# Charlotte Department of Transportation

## Memorandum

**Subject:** Rezoning Petition 08-051: Located on the northwest corner of South Tryon Street and Steele Creek Road

SITE PLAN

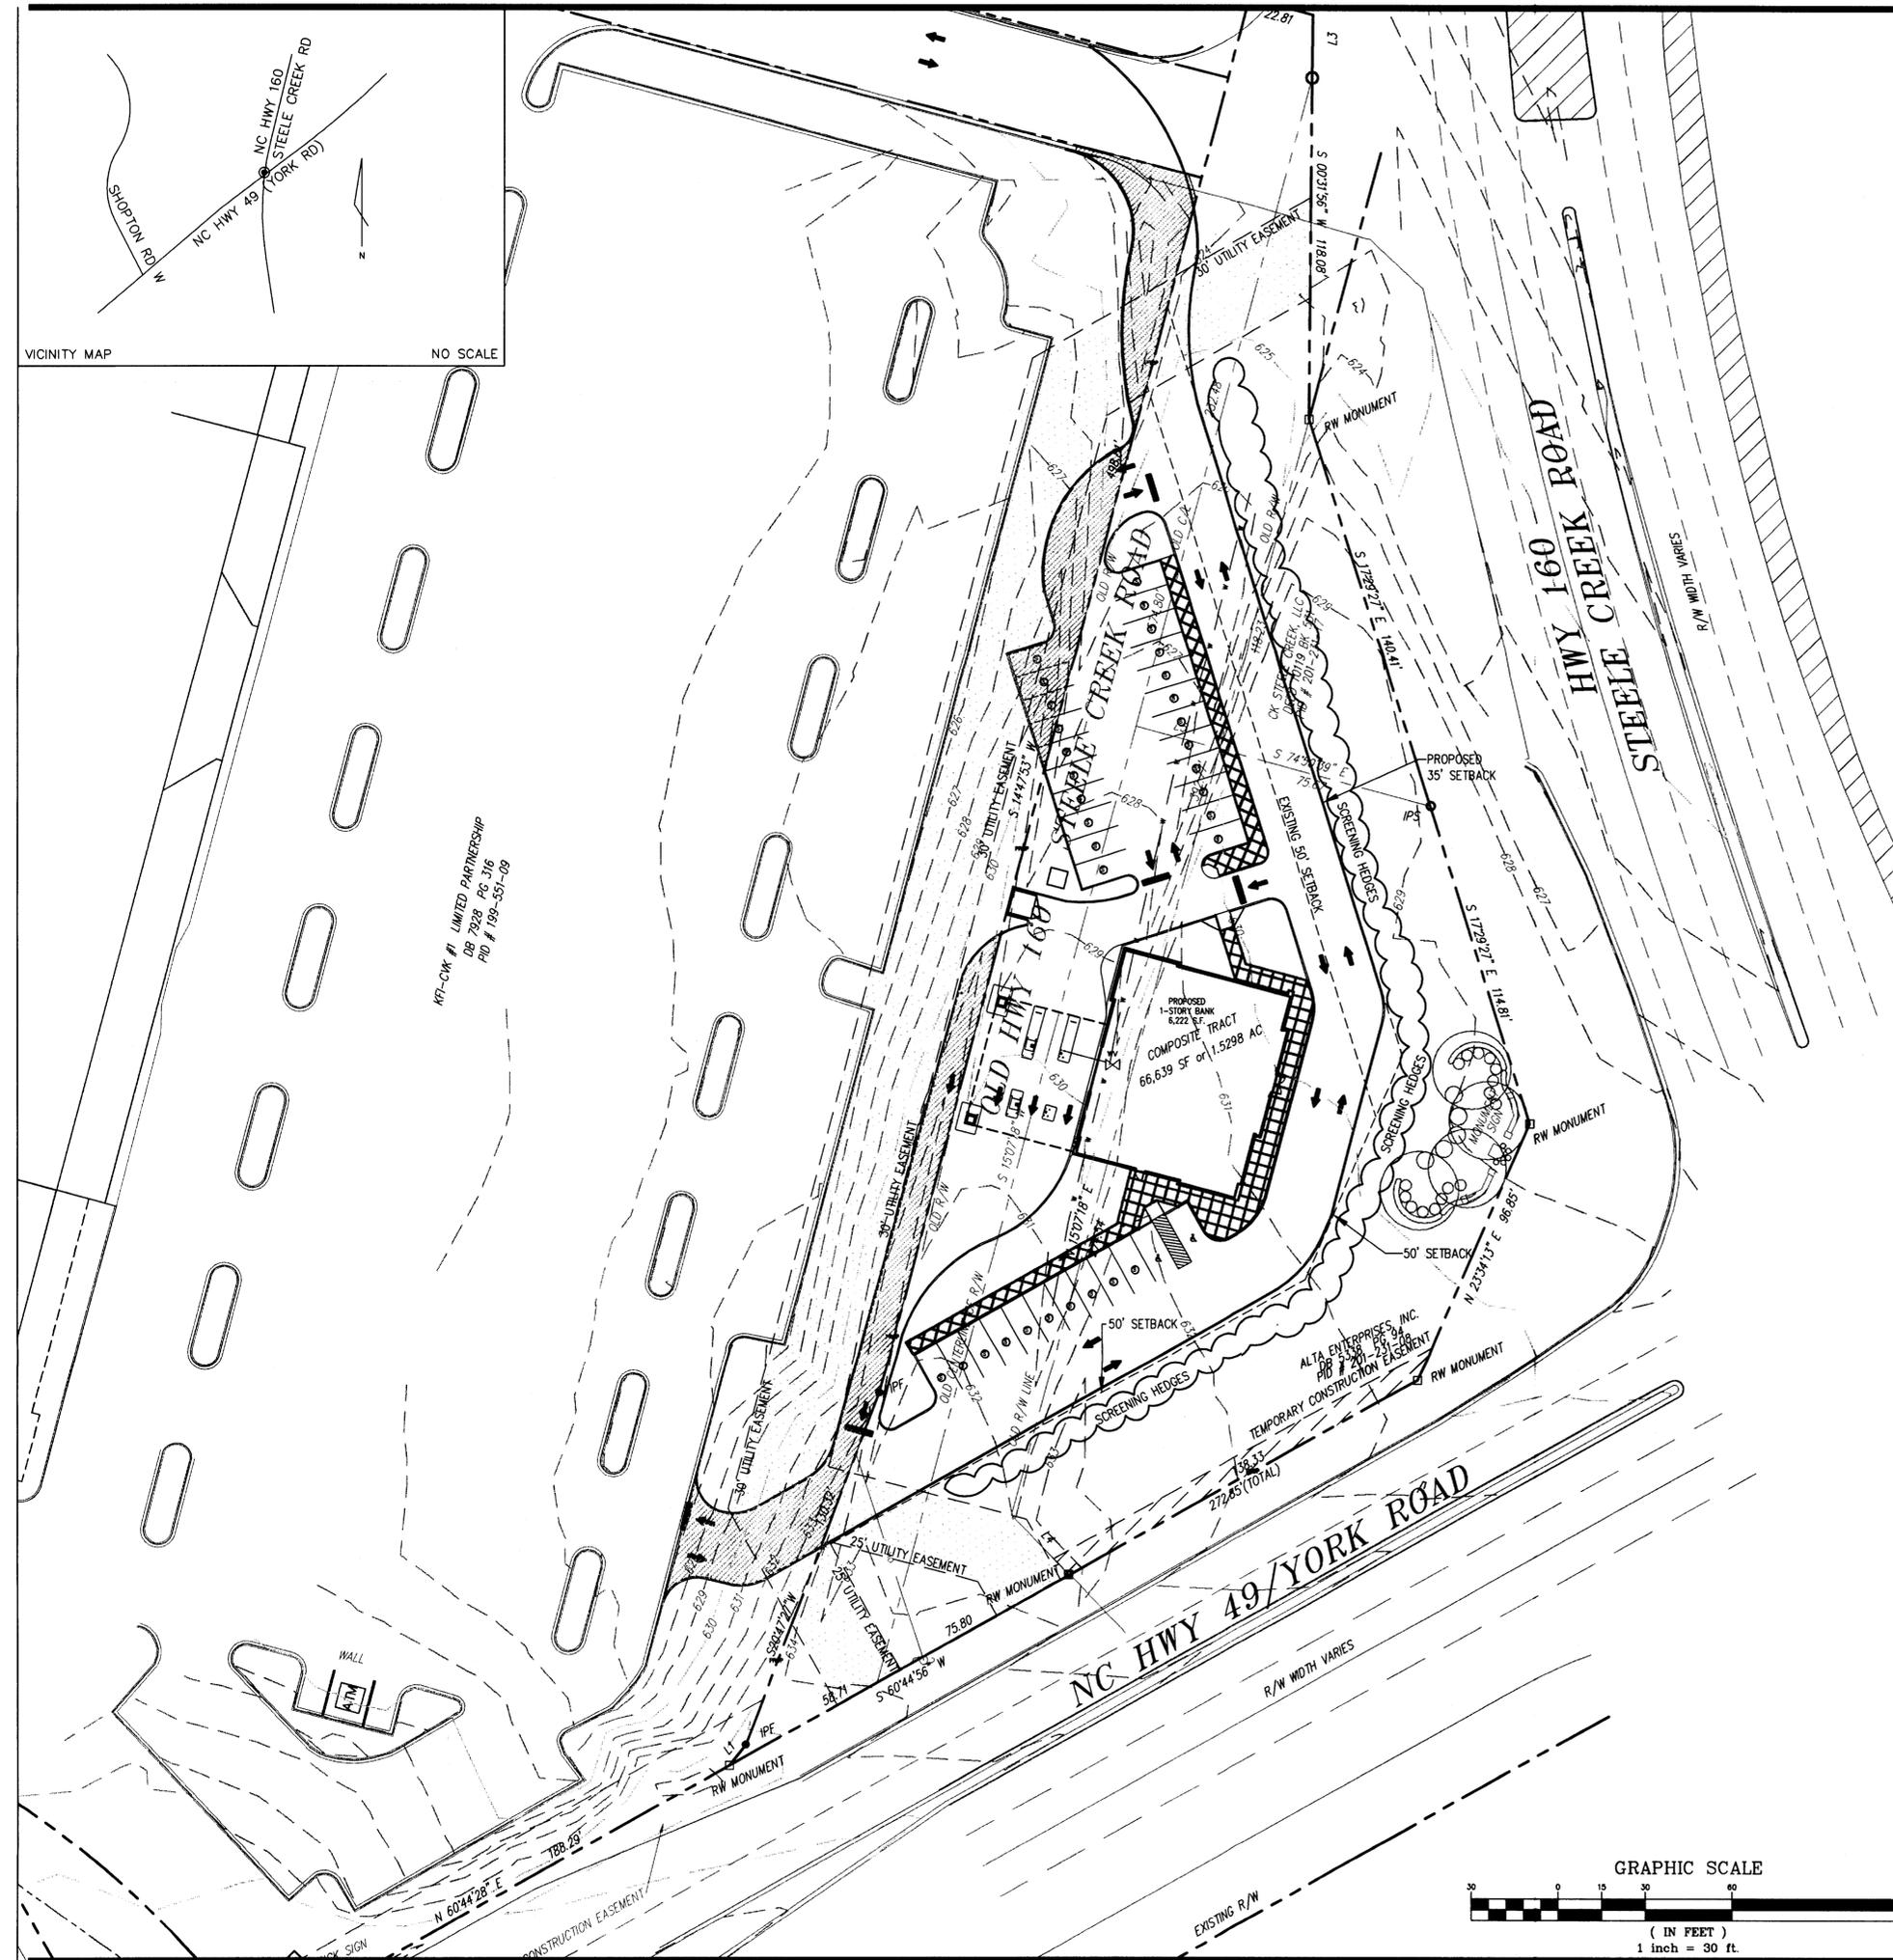
1. The site plan needs to be updated to show current conditions including, but not limited to, existing edge of pavement of the relocated street and curblines of adjacent development.
2. All access to this parcel is to be internal to the shopping center as shown. It should be noted on the plan that no access points will be permitted on Steele Creek Road and South Tryon Street.
3. The first driveway to the perimeter road located to the north of the proposed bank needs to be designed to operate as two-way between the perimeter road and the parking lot to avoid confusion and wrong way movements.

4. The one way driveway exiting the drive-thru windows needs to perpendicularly connect with the perimeter road to provide a more appropriate and comfortable angle for driver visibility/sight distance.
5. Although sidewalks are provided within the parcel, there is no sidewalk connecting the proposed bank with the shopping center. The sidewalk along the northern parking area needs to be extended along the perimeter road to the first internal shopping center intersection. The sidewalk located in front of the front loaded parking spaces on the south side of the proposed bank needs to continue to the perimeter road and then be extended to the shopping center parking lot.
6. The petitioner needs to provide 6-foot sidewalks and 8-foot planting strips along Steele Creek Road and 8-foot sidewalks and 8-foot planting strips along South Tryon Street.

1. The site plan needs to provide an internal system of 5-foot or wider sidewalks that connects building entrances to sidewalks along Steele Creek Road and South Tryon Street, preferably a direct route as possible to its intersection.

1. Petitioner needs to provide 8-foot sidewalks along South Tryon Street for an overland connector along this site (see comment 6 above).
